25 September 2014

Row No.	Submission	UGNSW Response
	SUBMISSION BY TfNSW and RMS	
1	<p>The TMAP included the following objectives:</p> <ul style="list-style-type: none"> • Adoption of Transit Orientated Development principles to maximize the use of public transport, walking and cycling • Manage the transport impacts of the North Ryde Station Precinct Project on surrounding sites and transport networks • Help reduce reliance on the private motor vehicle <p>TfNSW believes that in order for these objectives to be met the following statements of commitment should be given or otherwise conditions applied by Department of Planning and Infrastructure to achieve the following:</p>	<p>UGNSW supports these objectives for the North Ryde Station UAP and has prepared the development application (DA) in order to deliver one aspect of the proposed transport network contemplated by the TMap and the North Ryde Station Development Control Plan (DCP). In resolving the design of Station Street and Road 38 North as proposed in the DA, UGNSW has had to take into account all of the relevant site constraints and the requirements of the owner of the North Ryde Station South Site, whose co-operation is nec

Surveyor: JOHN NELSON PETERSEN	PLAN OF SUBDIVISION LOT 1 IN DP 863893	L.G.A.: RYDE CITY	Registered: 5.12.2008
Date of Survey: 3rd MARCH 2008		Locality: NORTH RYDE	
Surveyors Ref: D894-011b.dwg		Subdivision No: ECRL 445616	
		Lengths are in metres. Reduction Ratio 1: 600	DP1131774 P

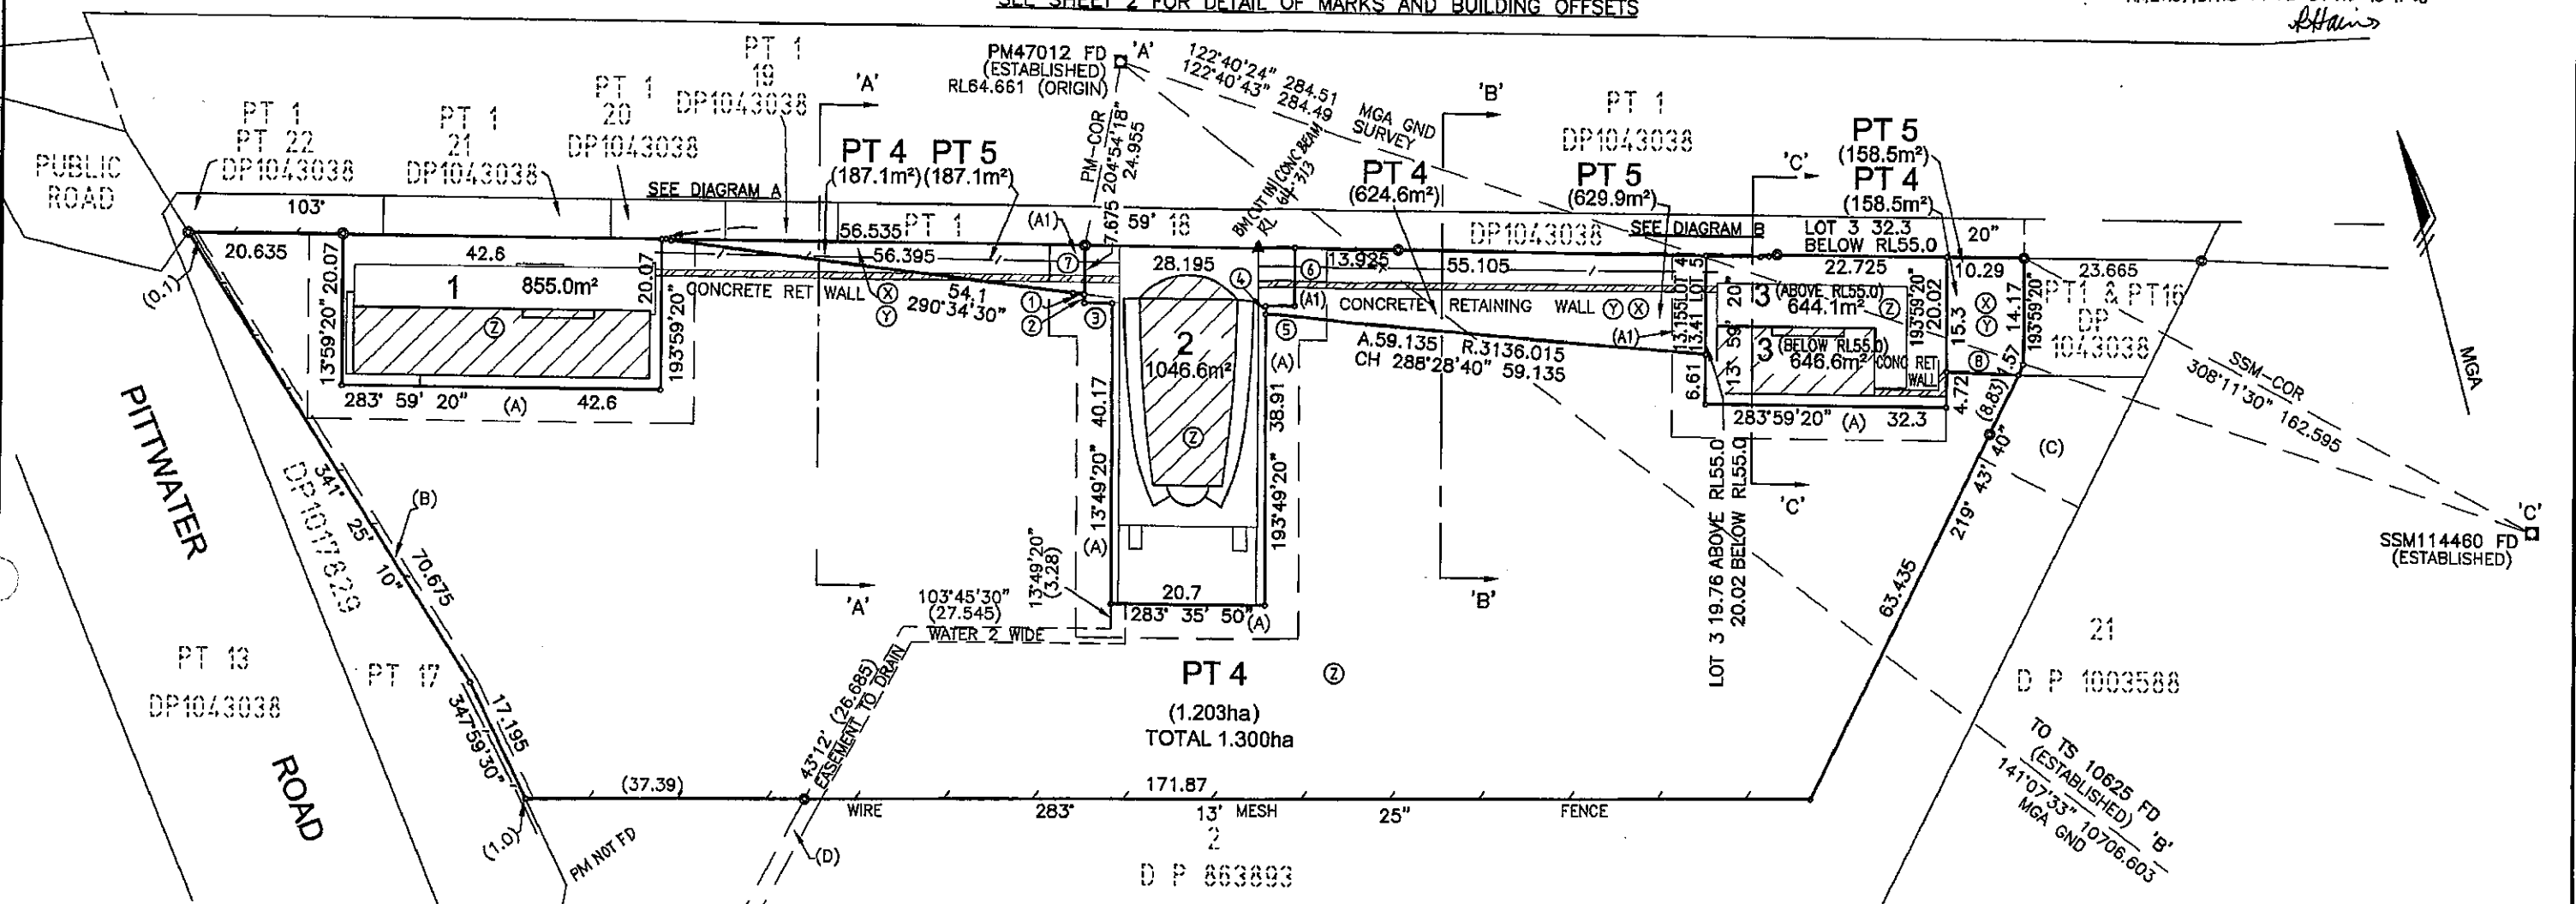
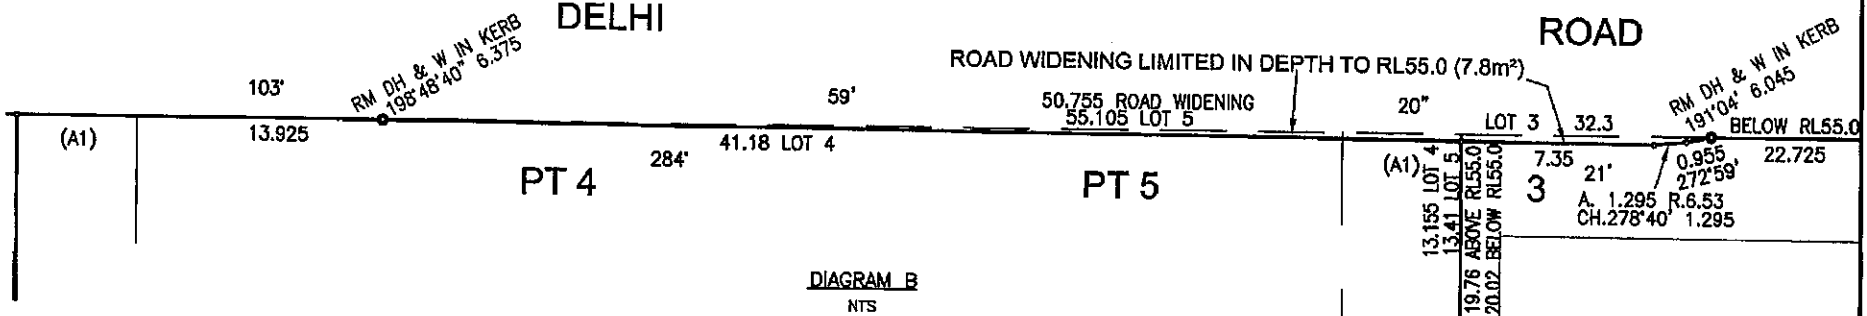
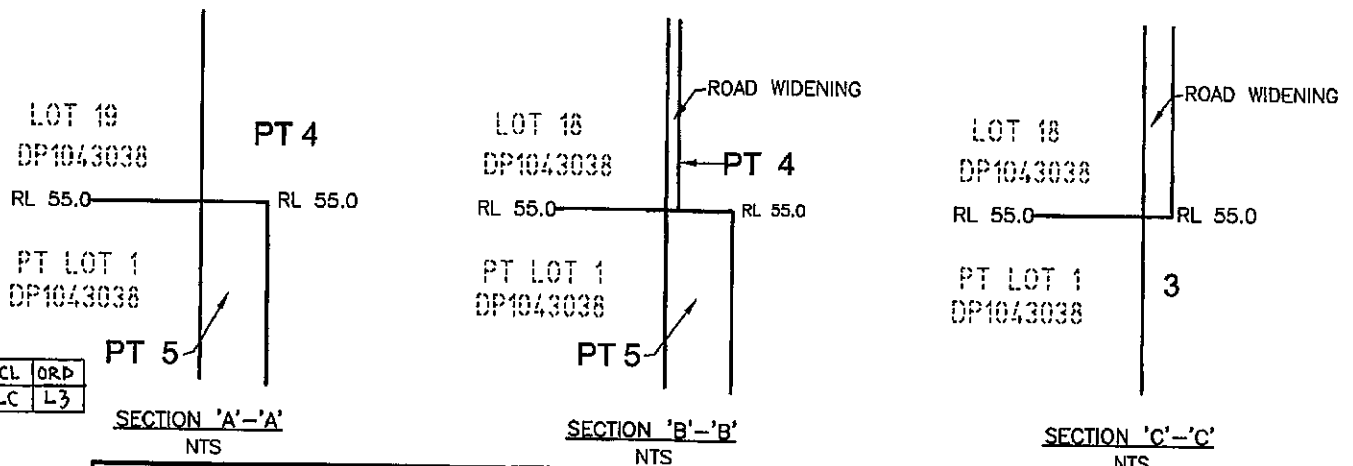
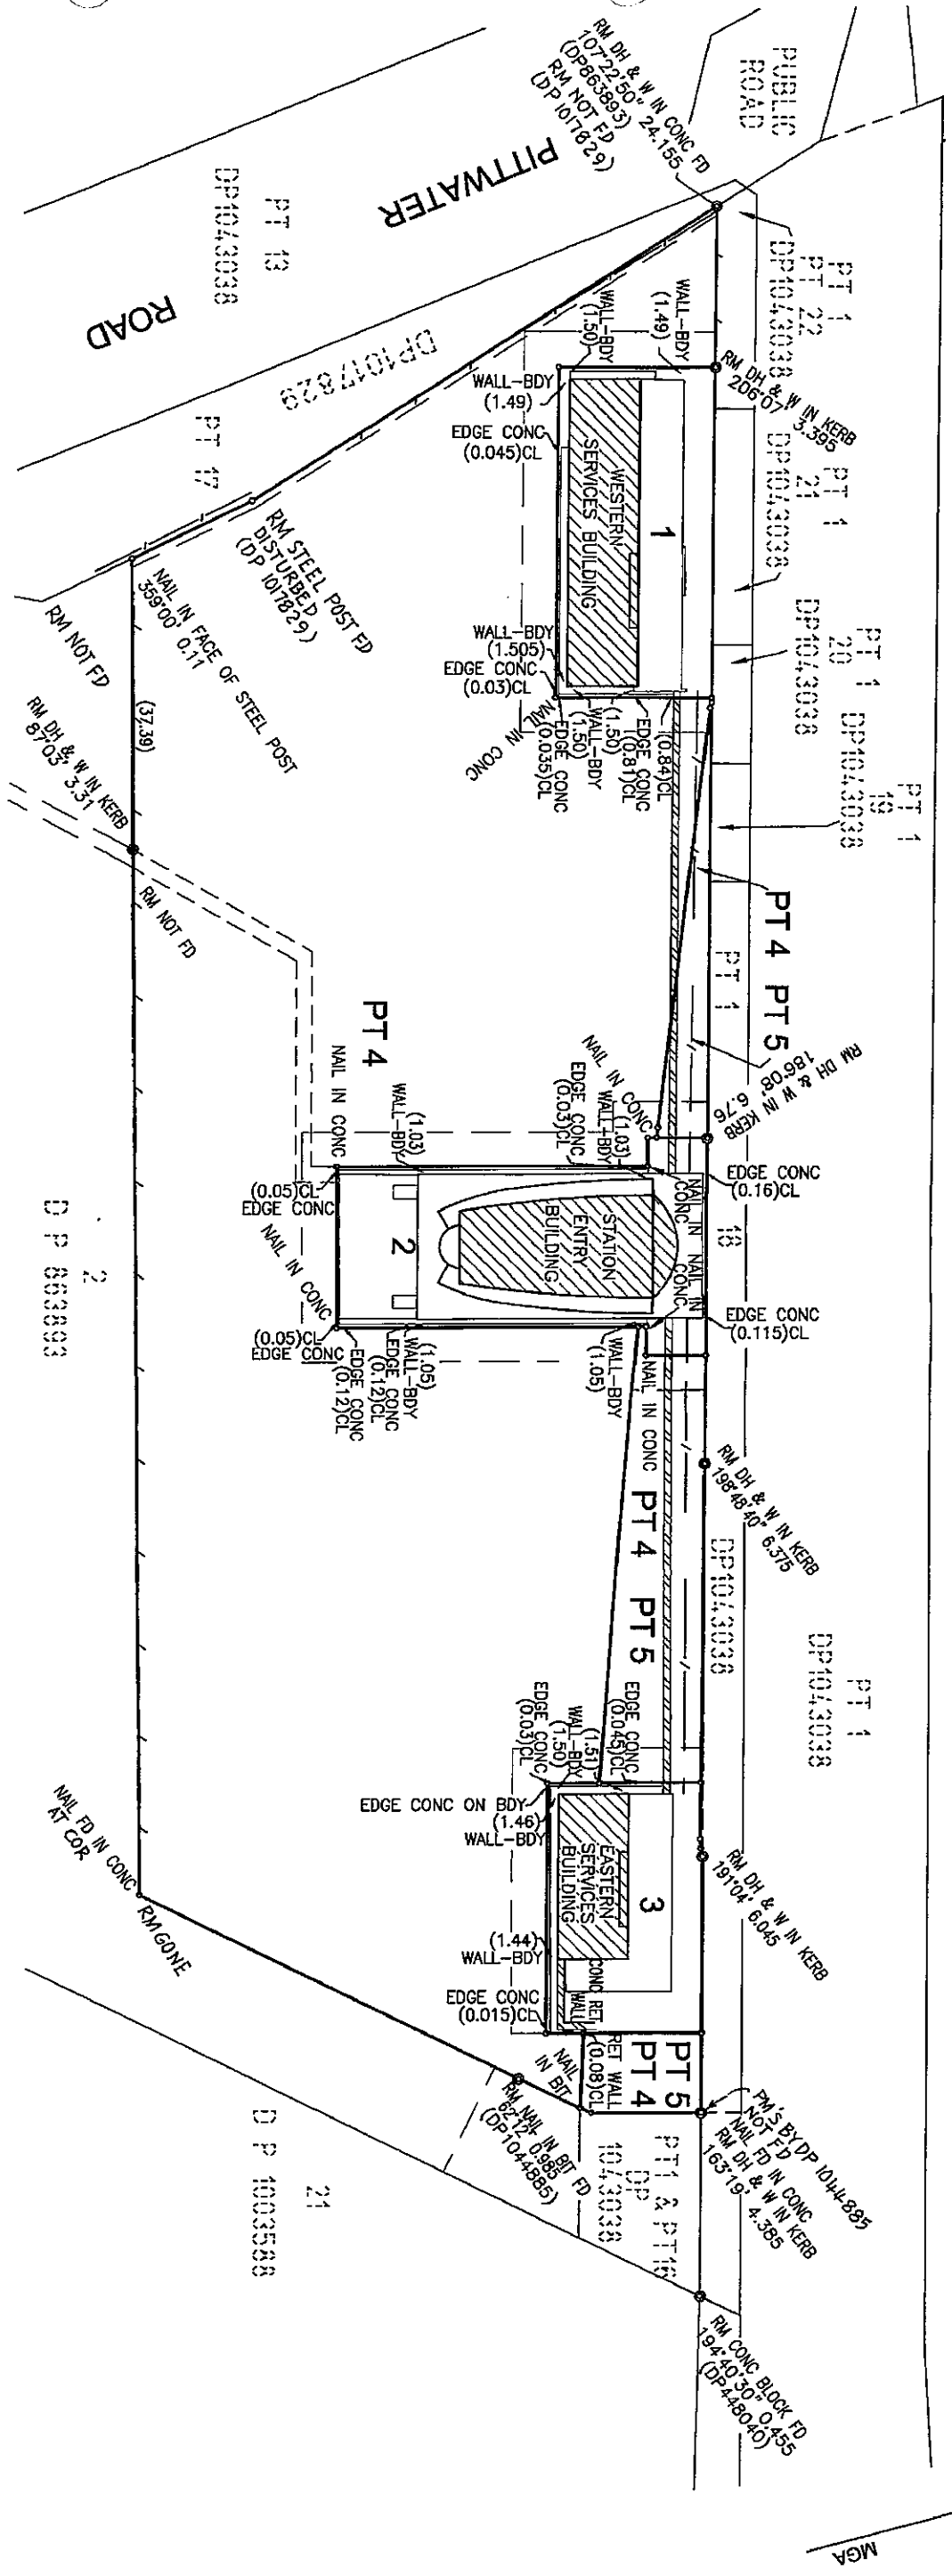
<p>These are identified in DP 1131774, DP 1187161, and DP 104833. It is noted that Drawing Number C0-01 Revision 4 prepared by Robert Bird Group includes a note that details of easements are contained in the Schedule of Easements and Stratum Statements on DP and Title Documents. Whilst this plan shows some of the easements it does not include an easement under DP 104833 which provides access to an existing substation located on the site. This easement must be addressed under any forthcoming development application. With regards to the proposed utilities Council has provided an indicative Lighting Plan which includes meter boxes and zones. This must be compatible with the proposed utility connections.</p>	<p>1043038(copy attached), which is relevant to the Site, there is no point in depicting the Right of Way Variable Width created by DP 863893 on Drawing Number C0 01 Revision 4.</p> <ol style="list-style-type: none"> 2. The Council's claim that <i>"This easement must be addressed under any forthcoming development application"</i> is, patently, not a matter which is relevant to this DA. 3. It is intended that the final electrical circuit design will satisfy Ausgrid's requirements in a manner which is compatible with Council's reasonable requirements concerning street lighting.

22	<p>Utilities & services</p> <p>Council's records indicate that the subject site is affected by easements (including but not limited to access right-of-ways and drainage easements).</p>	<ol style="list-style-type: none"> 1. This submission appears to be in error because DP104833 (copy attached) relates to land at Tenterfield and is therefore irrelevant. If this was intended to be a reference to DP
